Please ask for: Mrs D Johnson
Email: daun.johnson@arun.gov.uk
Telephone: 01903 737762
Our Ref: LU/77/25/PL
Your Ref:
Date: 28th April 2025

Development: Change of use of ground floor of existing building from light industrial (Class B2/E) to residential (Class C3), to be used as ancillary accommodation including workshop, games room and utility space, with all habitable accommodation located and expanded on the first floor. This application affects the character and appearance of the Littlehampton River Road Conservation Area and is in CIL Zone 4 (Zero Rated) as other development.

Location: 49 River Road Littlehampton BN17 5BZ

Existing First Floor Plan

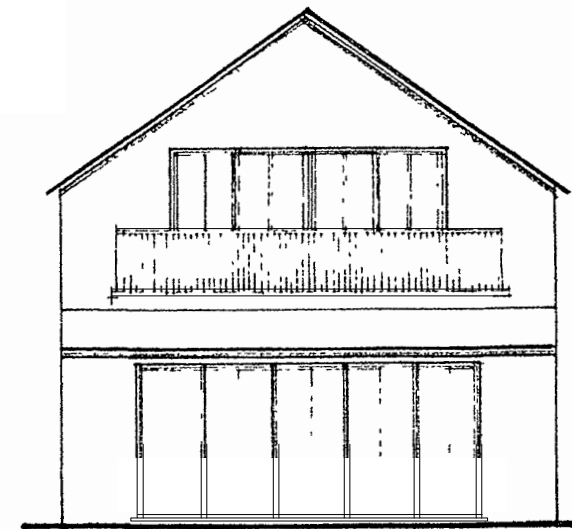
Please show the roof lights on the existing and proposed first floor plans.
